PCD Project Manager_2026-06-10_008 - Architectural Elevations.pdf Markup Summary

HONOR CHARTER SCHOOL

K-8, 2-story educational facility at 8250 Bent Grass Meadows Drive, Peyton, Colorado (Parcel no. 5301000038). The overall square footage will be approximately 45,000 sf; providing 27 classrooms (3 per grades K-8), elective classrooms serving Art, Science, and Music, 3 small group classrooms for pull-out/support services, media center, MS regulation size Multipurpose gym/cafeteria with divider curtain, warming kitchen, offices, group and staff restrooms, nurse, conference room, lobby and staff support areas. This school design will be functional and easily maintained. The site design will allow adequate parking, onsite traffic management, and exterior play fields, with care towards storm water management.

AS101

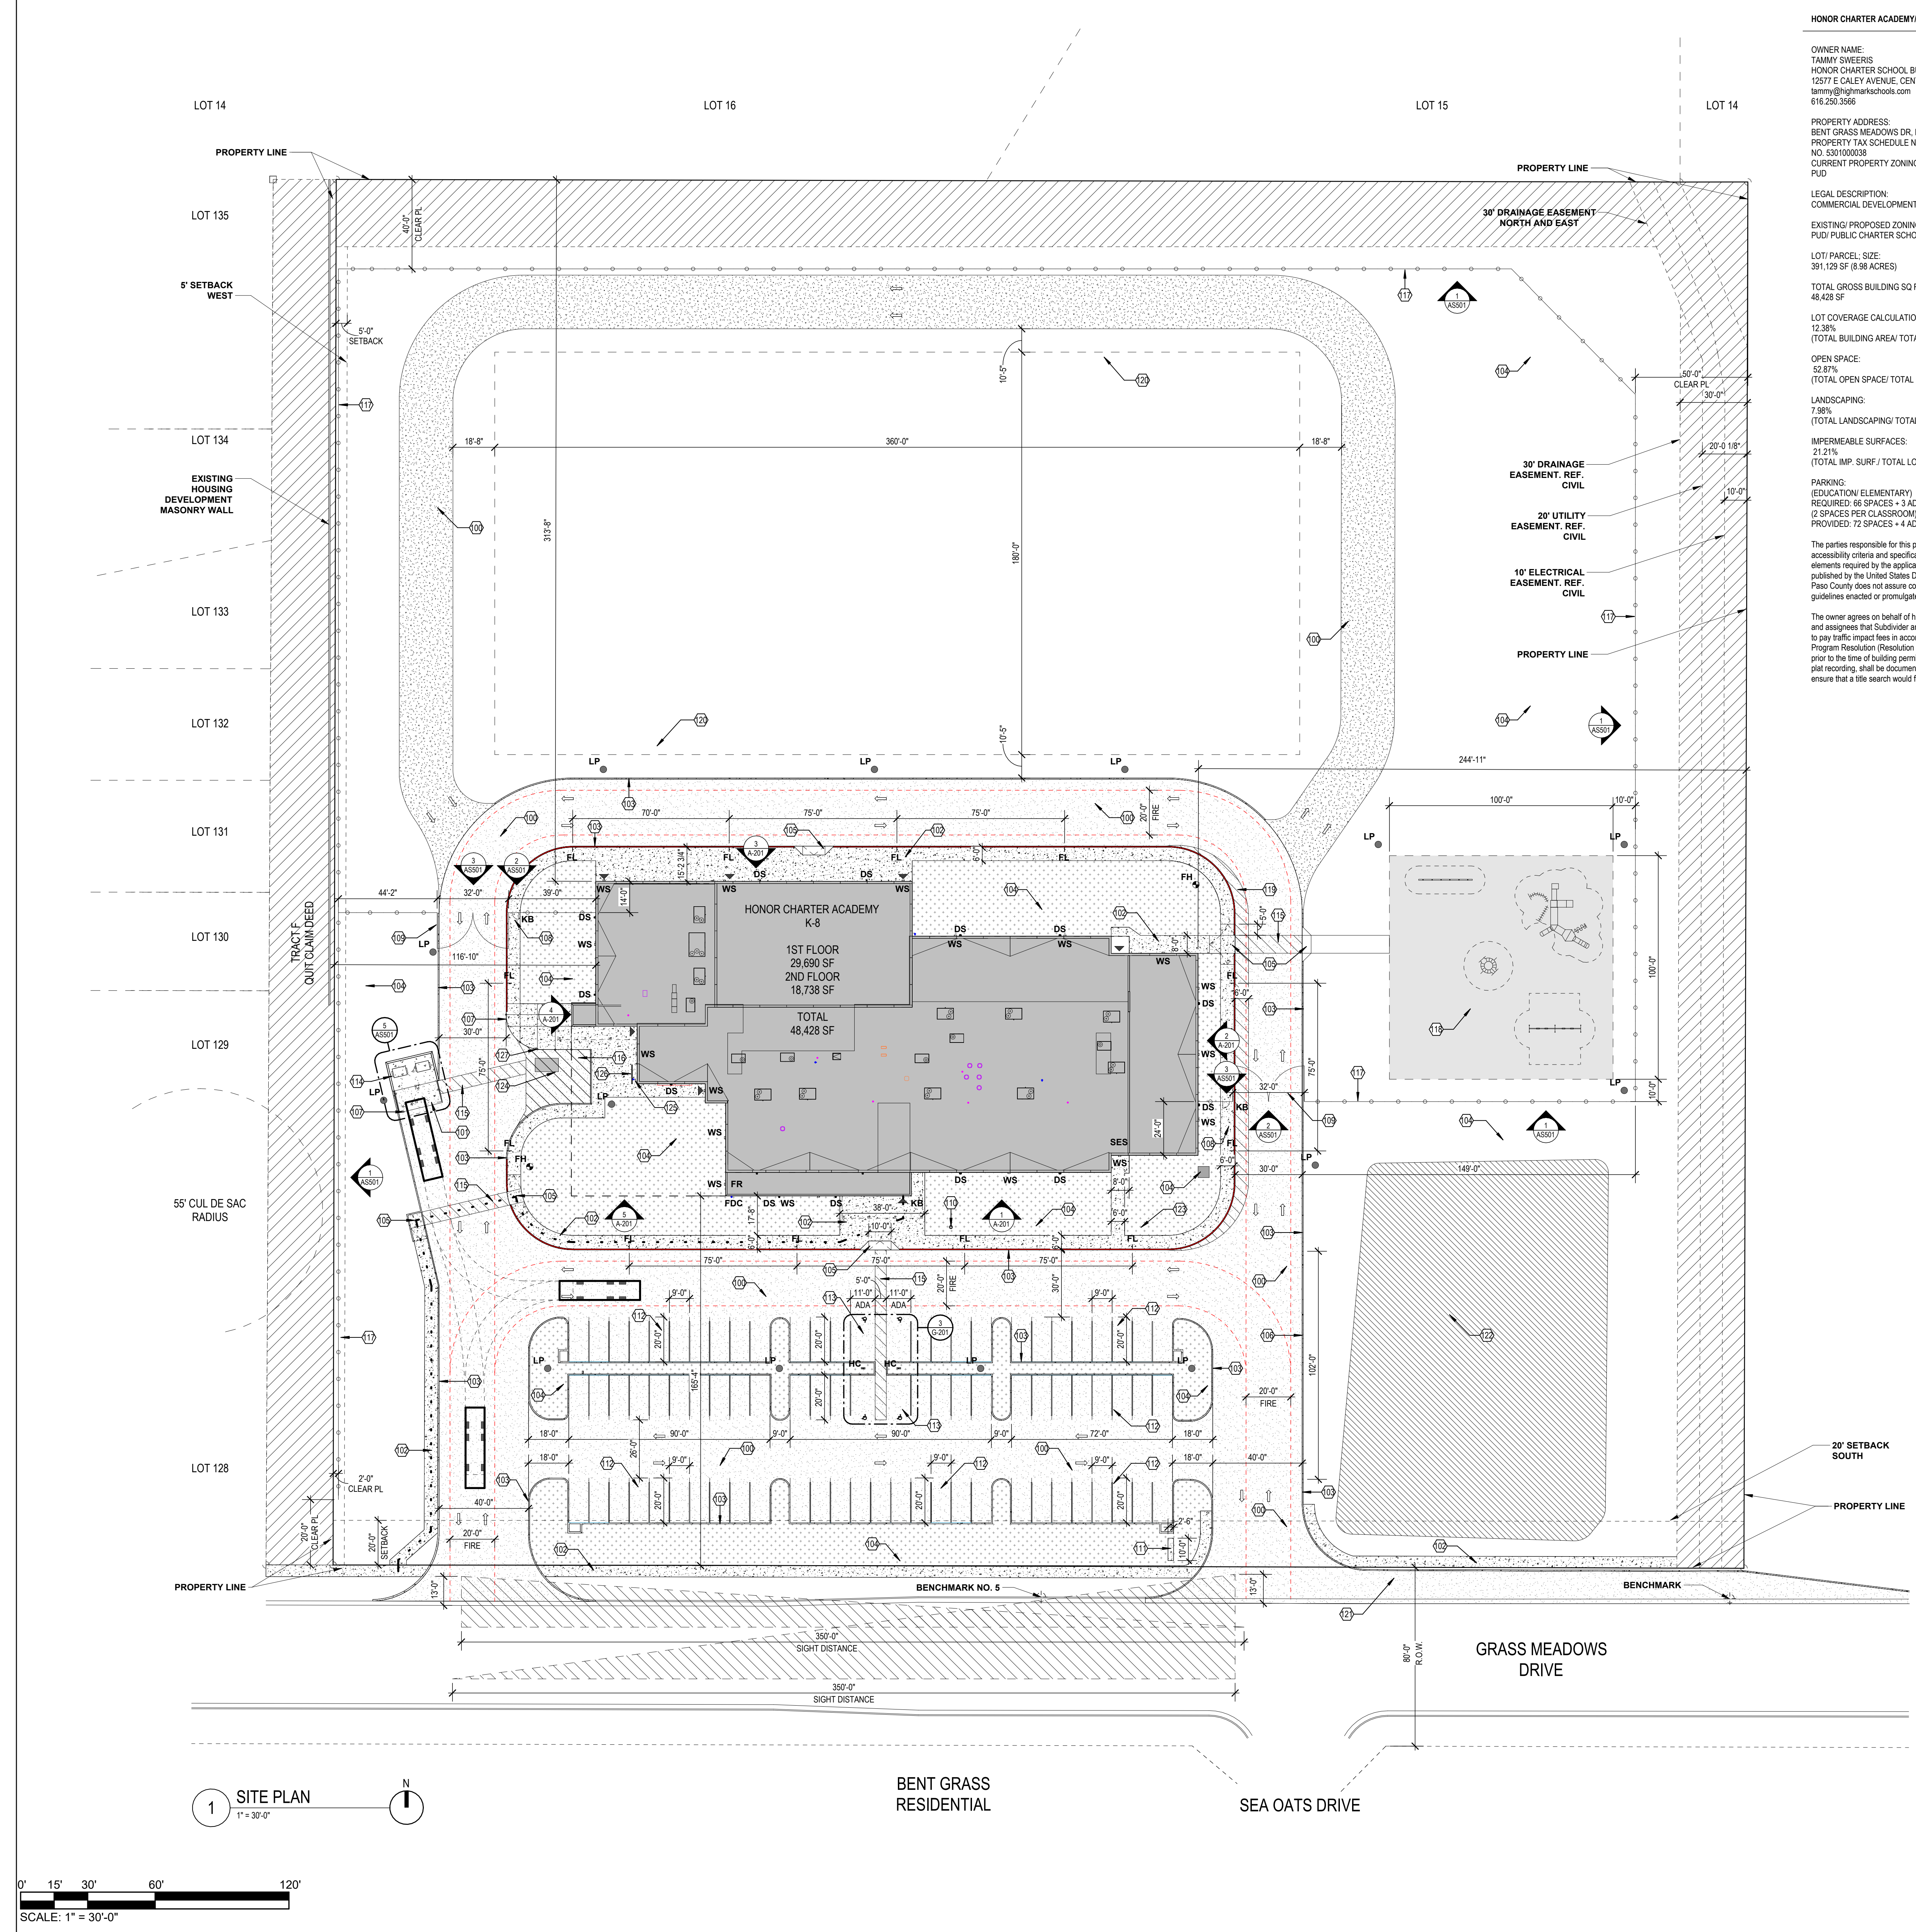
Buffers are required
at northern and
western prop lines

1 CHAIN LINK FENCE ELEVATION
1/2" = 1'-0"

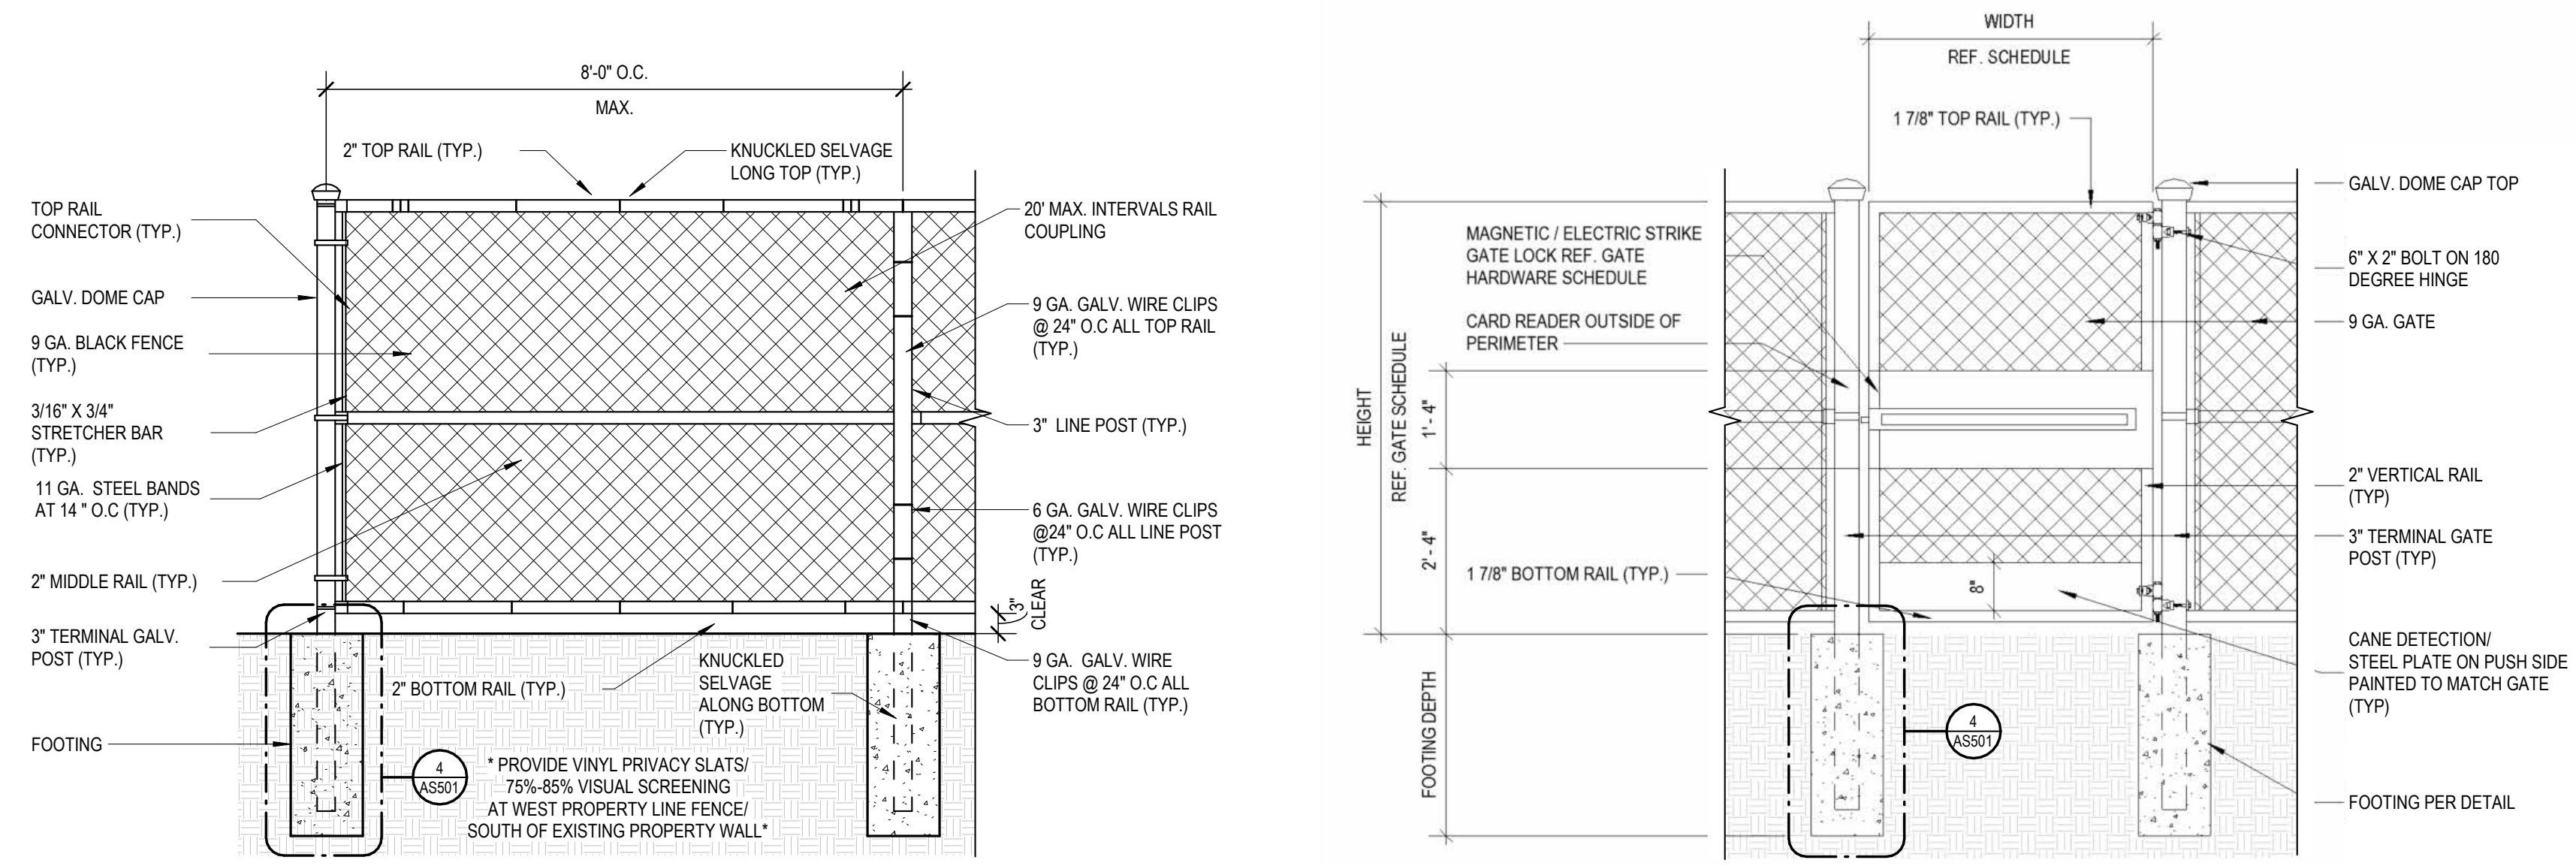
are there any sports fields,
bleachers , screening
walls/fences/ playgrounds

THERE ARE NO DEDICATED SPORTS FIELDS, OR SPECTATOR SEATING IN THE PROJECT.

HOWEVER, THE OPEN FIELD SPACE TO THE NORTH OF THE BUILDING WAS DESIGNED TO BE LARGE ENOUGH TO ACCOMMODATE A FUTURE FULL SIZED SPORTS FIELD.

THE OPEN FIELD AREA IS NATURAL GRASS, AND WILL BE USED AS OPEN PLAY AREA FOR FAIR WEATHER GYM CLASSES/ RECESS ACTIVITIES. ALL FIELDS AND PLAYGROUND AREAS ARE WITHIN A SECURED FENCE WHICH WILL BE LOCKED AFTER SCHOOL OPERATING HOURS.

THERE WILL BE A DEDICATED PLAYGROUND STRUCTURE WITHIN THE SECURED AREA FENCE, EAST OF THE MAIN DRIVEWAY. PLAYGROUND EQUIPMENT WILL BE PROVIDED BY A SEPARATE VENDOR, NOT DESIGNED BY THE ARCHITECT. PLEASE REFER TO AS101 FOR PROPOSED PLAYGROUND LAYOUT. ALSO REFER TO ATTACHED PLAYGROUND EQUIPMENT VENDOR DOCUMENTS FOR ADDITIONAL INFORMATION.

THERE ARE NO ADJACENT OCCUPIED PROPERTIES TO THE NORTH OR EAST. THERE IS AN EXISTING MASONRY SCREENWALL AT THE WEST PROPERTY LINE WHICH SCREENS THE ADJACENT RESIDENTIAL DEVELOPMENT (IDENTIFIED ON SHEET AS101).

CHAIN LINK FENCING WILL BE PROVIDED AROUND THE PROPERTY (AS SHOWN ON SHEET AS101). CHAIN LINK PRIVACY SLATS WILL BE ADDED TO THE CHAIN LINK FENCE AT THE SOUTHEAST PROPERTY LINE (BEGINNING WHERE THE EXISTING RESIDENTIAL MASONRY SCREEN WALL ENDS/ TO THE SOUTH PROPERTY LINE). PLEASE REFER TO SITE DETAILS SHEET AS501 FOR FENCING ELEVATIONS AND DETAILS.
